Subject: Third-Party Geotechnical Engineering Review - Permit# 2011-119
Xing Hua Group LLC
Mercer Island Mixed-Use Development
2885 78th Ave SE
Mercer Island, Washington

Wood Environment & Infrastructure Solutions, Inc. (Wood) presents this letter that summarizes our third-party geotechnical engineering review of the proposed ground improvement design for the Mercer Island Mixed-Use Development. Wood reviewed the following documents:

## Appendix A: Structural Loading

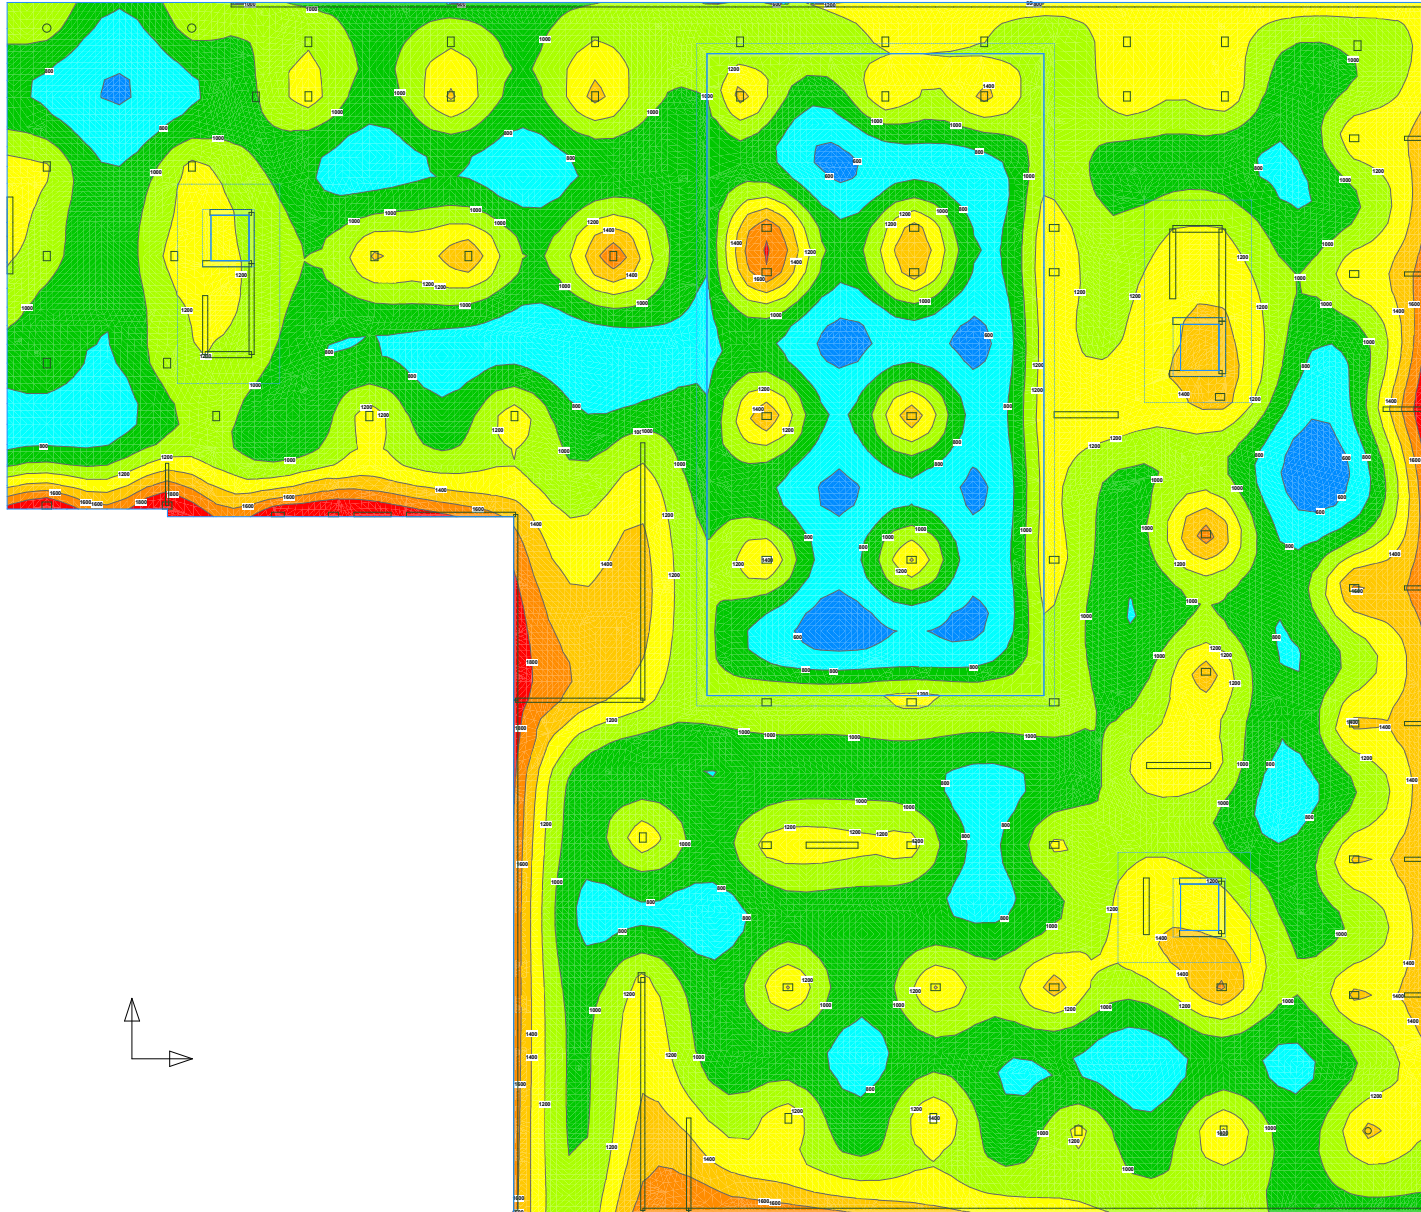
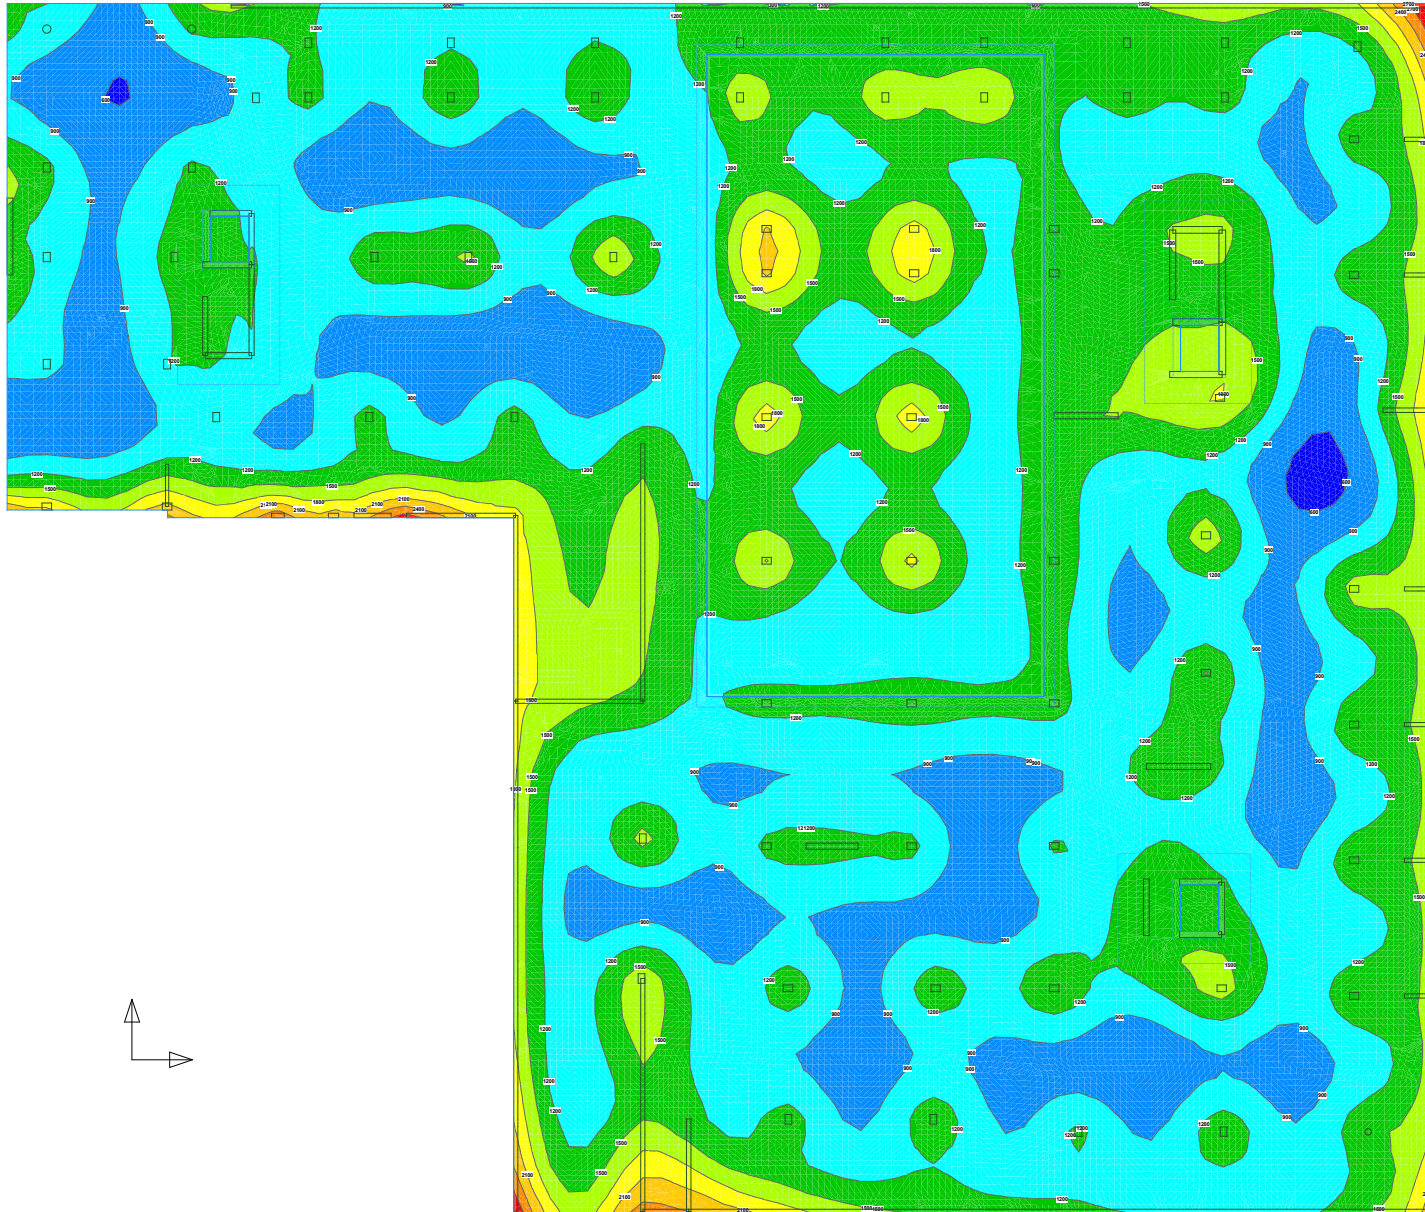
- c. Geopier Northwest says they designed for a maximum bearing pressure of 4,000 psf (with no supporting calculations), however it can be increased by another 1/3 for seismic loading. They go on to state they designed for the average bearing pressure of 1,500 psf based on actual loads. They also state that they designed for 60 kips over 36 sf, which is 1,667 psf.

- d. All three documents should clearly state the same design bearing pressures and/or subgrade modulus for the mat foundation.
4. The tolerable total settlement and differential settlement should be clearly stated since the Geopier analyses calculate settlement. The structural engineer should provide the settlement tolerance or approve the estimate settlement by Geopier Northwest.
